**MASTER DEVELOPMENT DRAINAGE PLAN FOR
AUTUMN HILLS (NE4 SEC 36-12-65) SKETCH PLAN
EL PASO COUNTY, COLORADO**

AUGUST 2022

MERIDIAN HILLS LLC

TERRA NOVA ENGINEERING, INC.

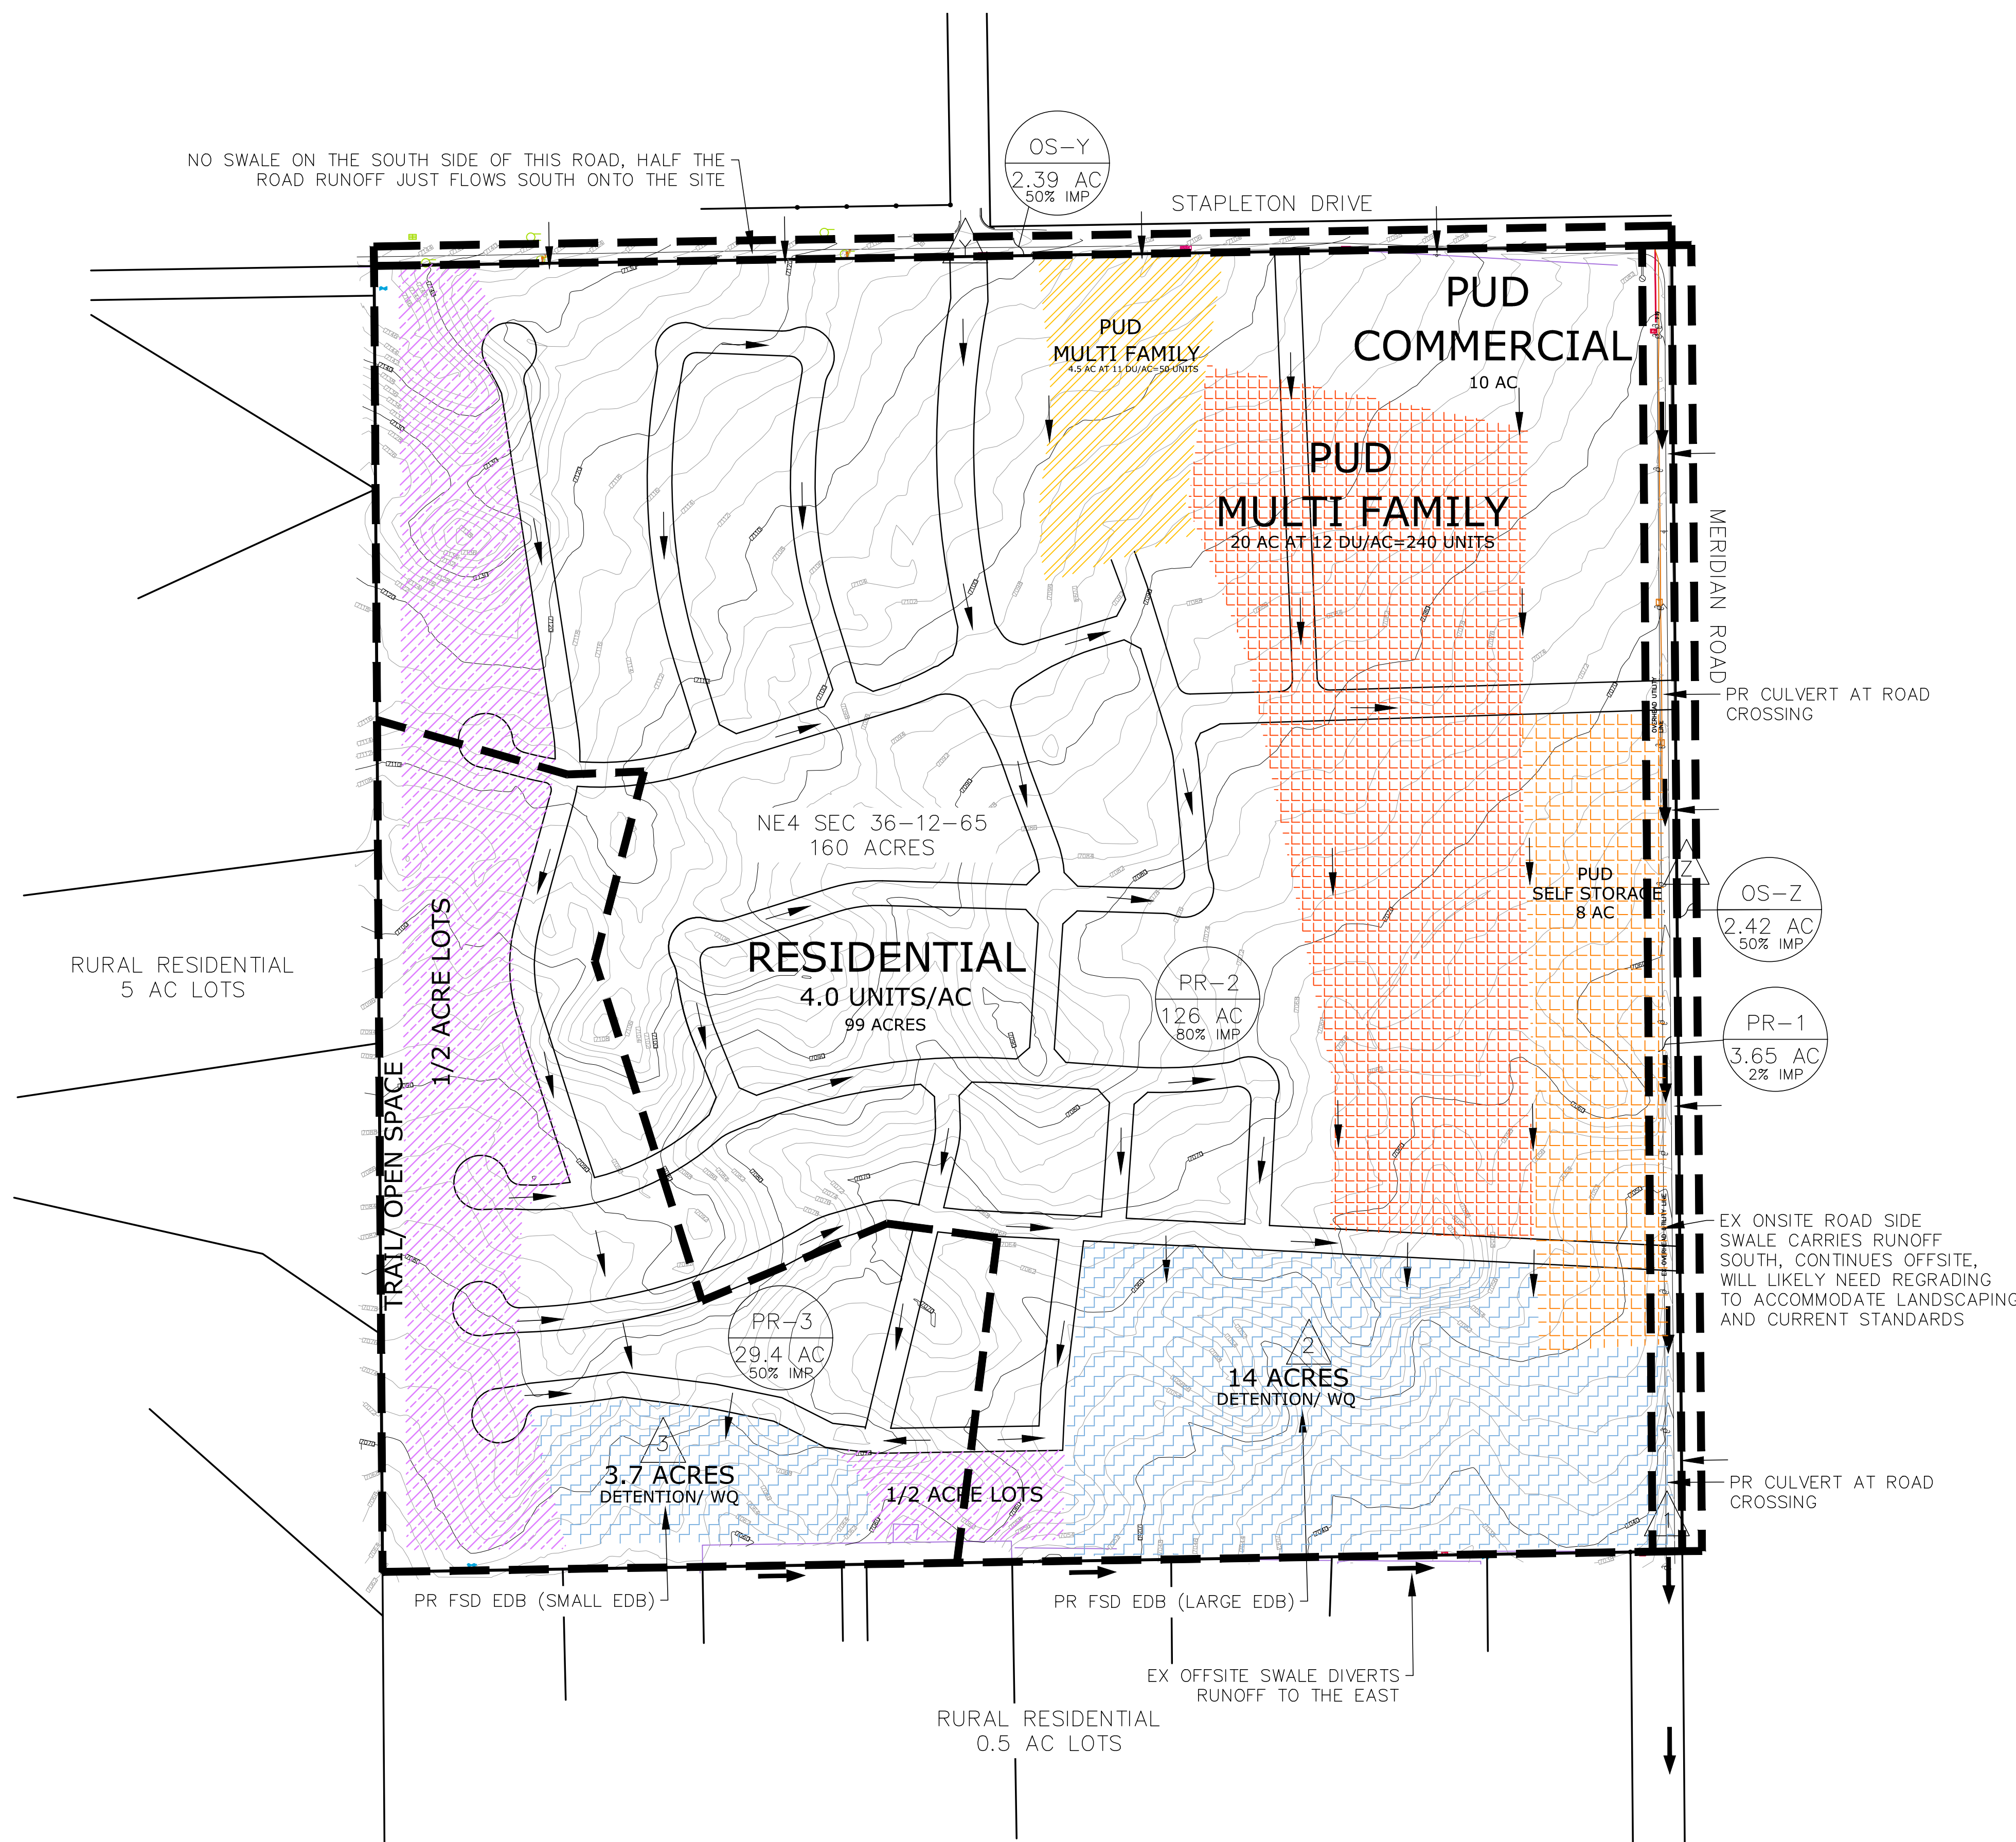
This should be proposed basin PR-1 per the drainage map

This should be PR-2 per the drainage map

Update PR-1 flow and impervious assumption to account for the widening of Meridian Road to its ultimate cross section.

Identify the anticipated culvert size and the road side ditch.

Elaborate on the assumption. The hydrology needs to account for the Stapleton Drive widening.

Please clarify that you are referring to DP1 and not the offsite swale south of the pond.

State whether or not the proposed ponds will mitigate the increase in flow caused by the development. Provide a comparison of the historic flows leaving the site and the developed flows that will need to be mitigated.

Please state what the ponds will be designed to release at. Will it be historic rates?

Identify where the flow from this offsite swale is conveyed to. Are improvements needed to this swale? what are the existing conditions? Is the existing swale contained within a drainage easement as it appears to be within residential lots? Please address.
